RIMINGTON & MIDDOP
 PARISH COUNCIL

RESPONSES TO PLANNING APPLICATIONS

3/2011/00596 tennis Court at Denis Field

drawing
PLANNING
Proposed Tennis Court

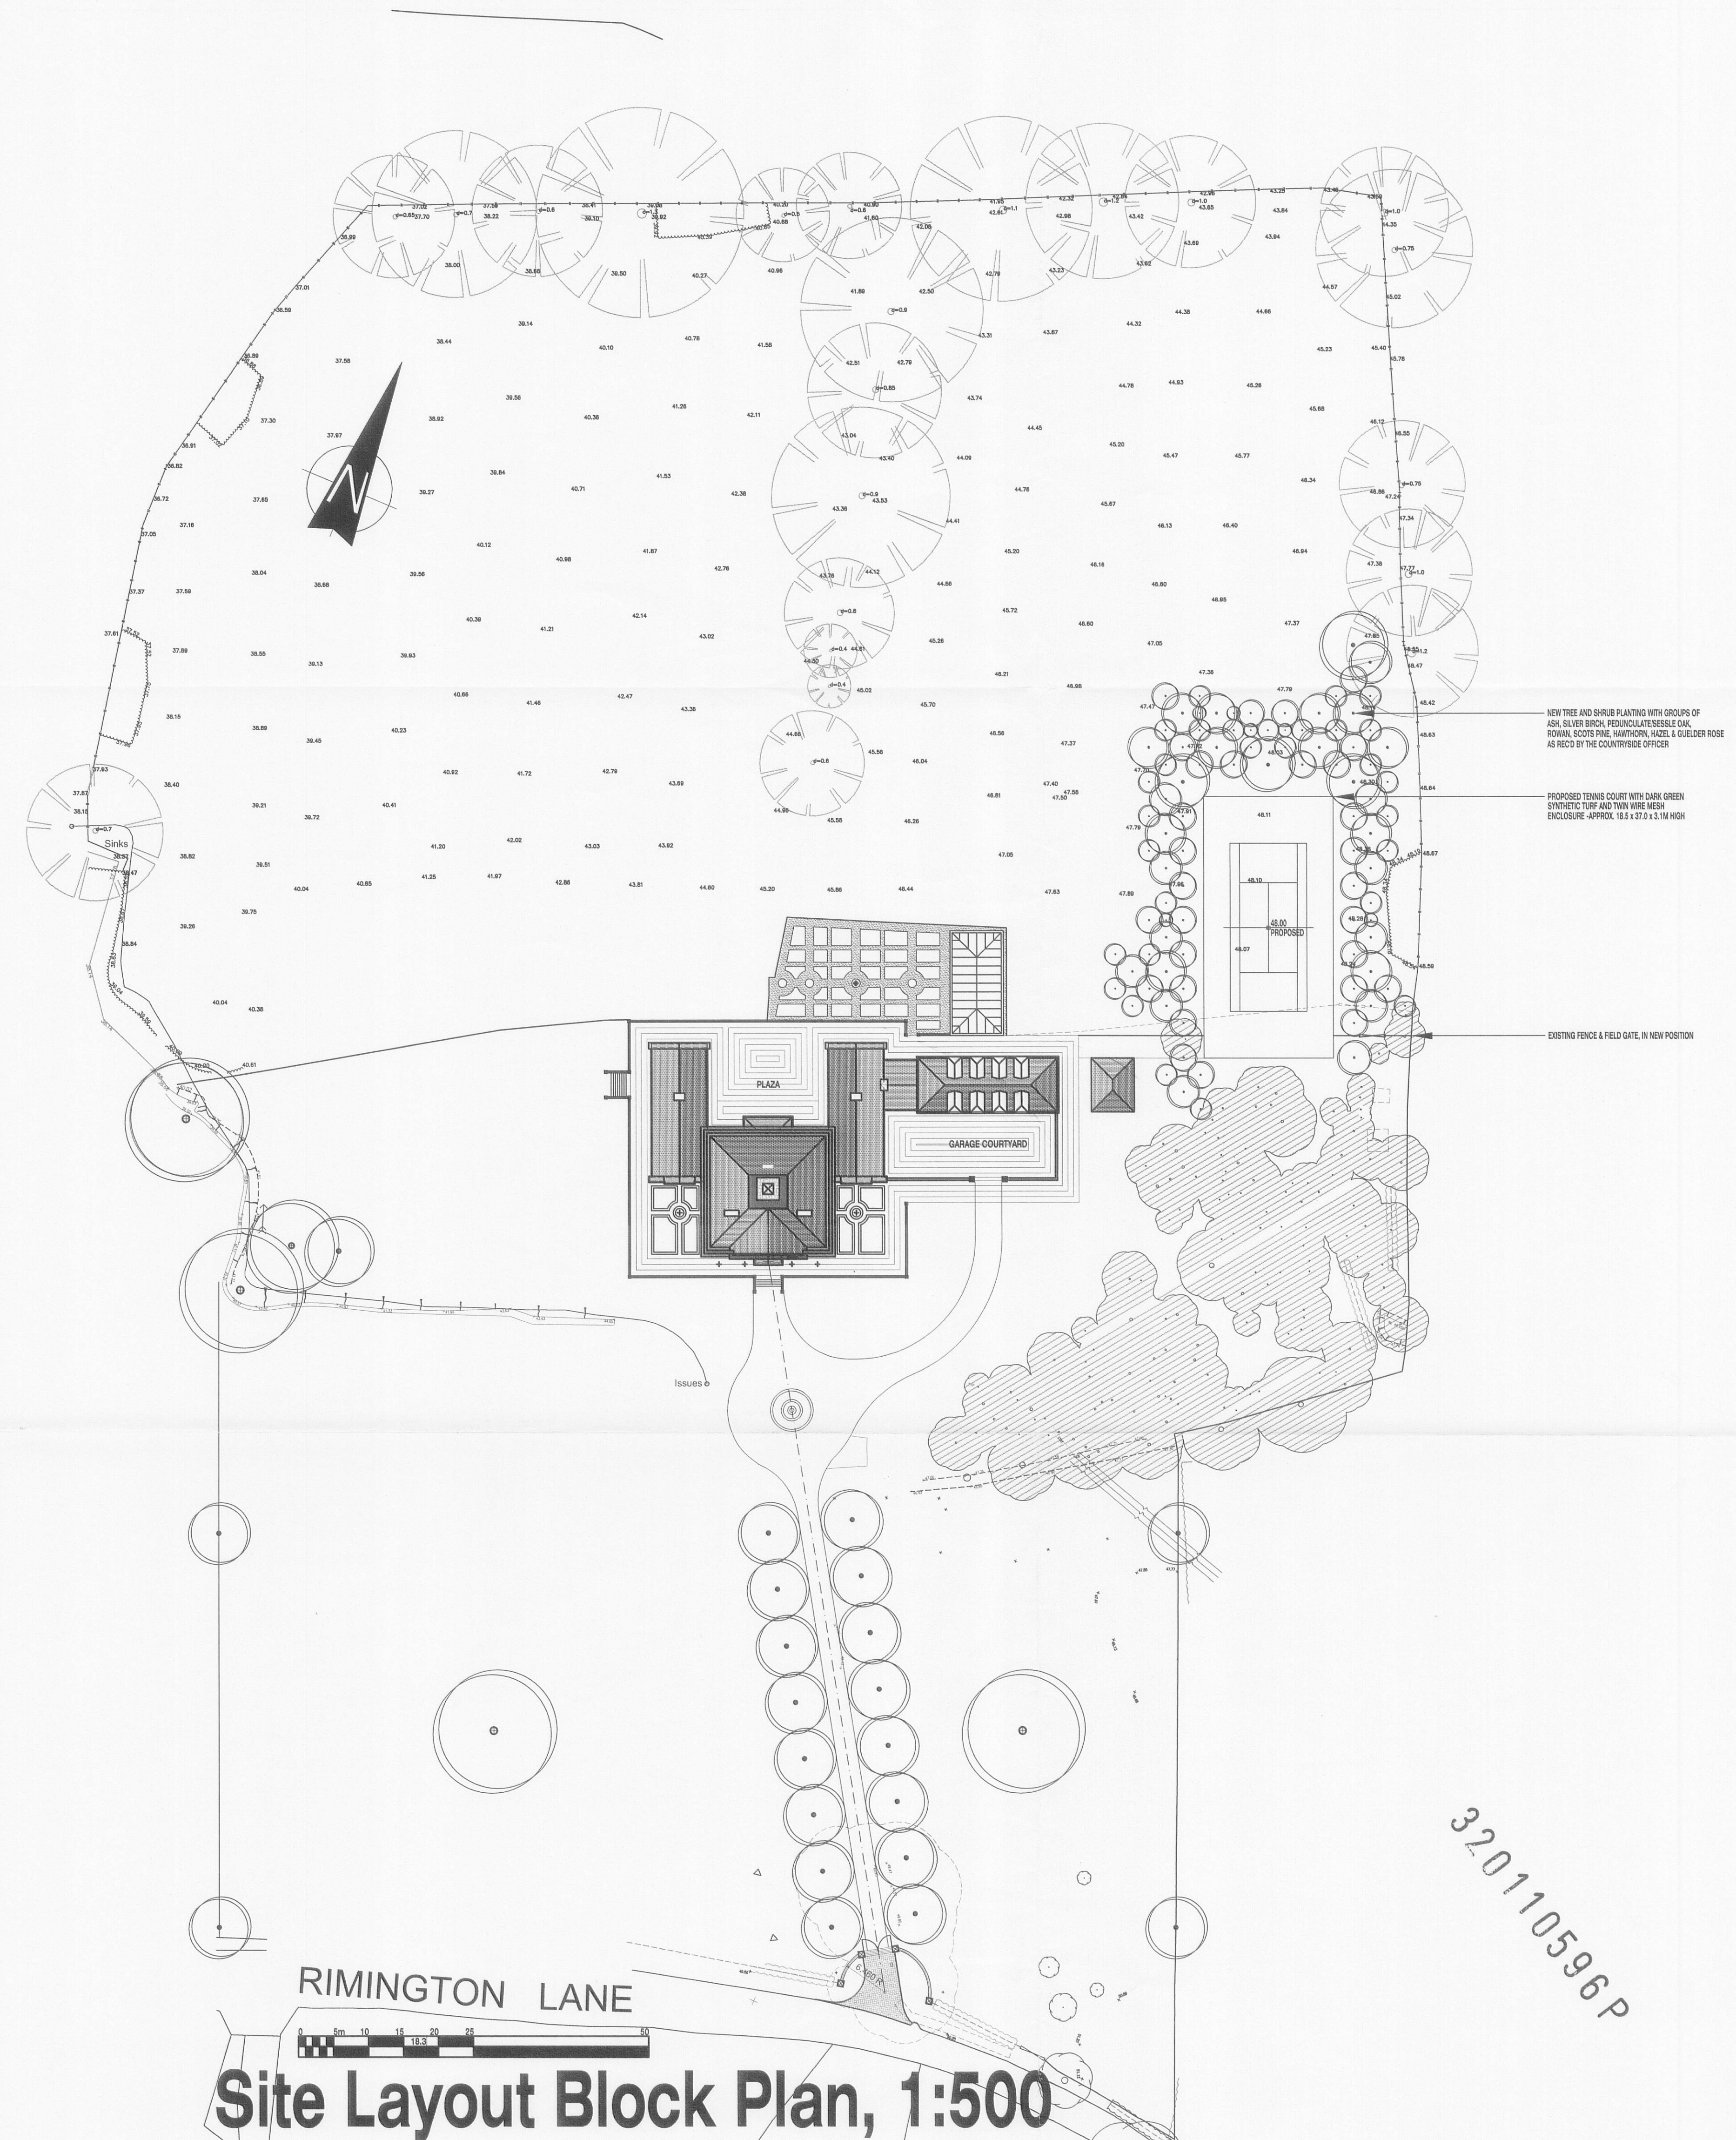
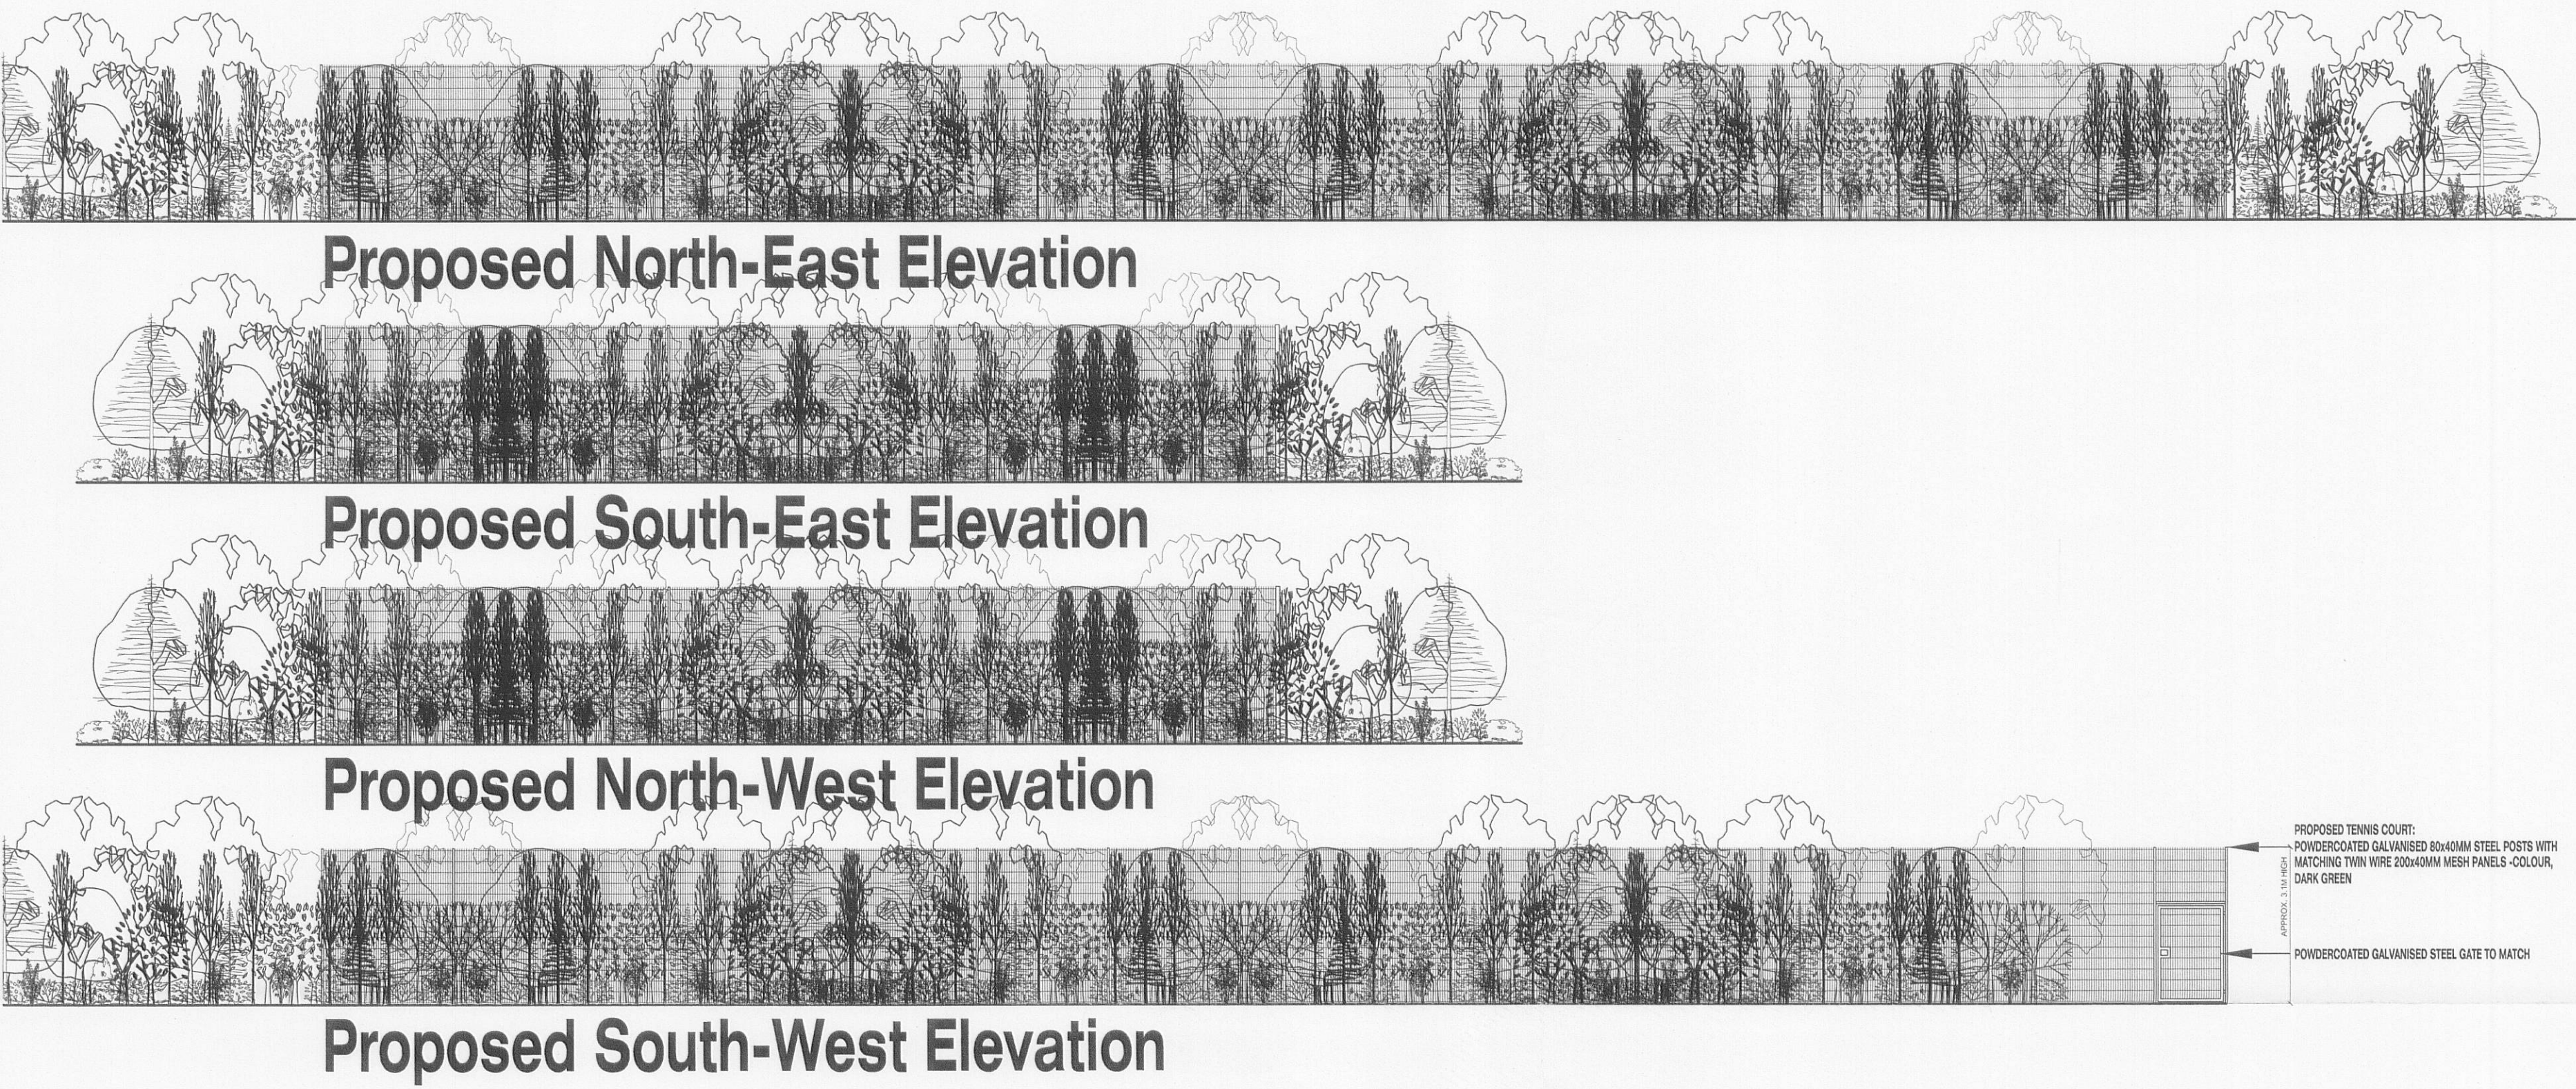
The P C has no alternative but to object to this in order to remain cosnistent with its earlier objections to other non agricultural developments on land which has agricultural curtilege The site chosen for the court is agricultural land and although the P C is sure that consstent with the other developments on this site th court will be well built and in this case well screened it is stil a domestic use of non domestic land.
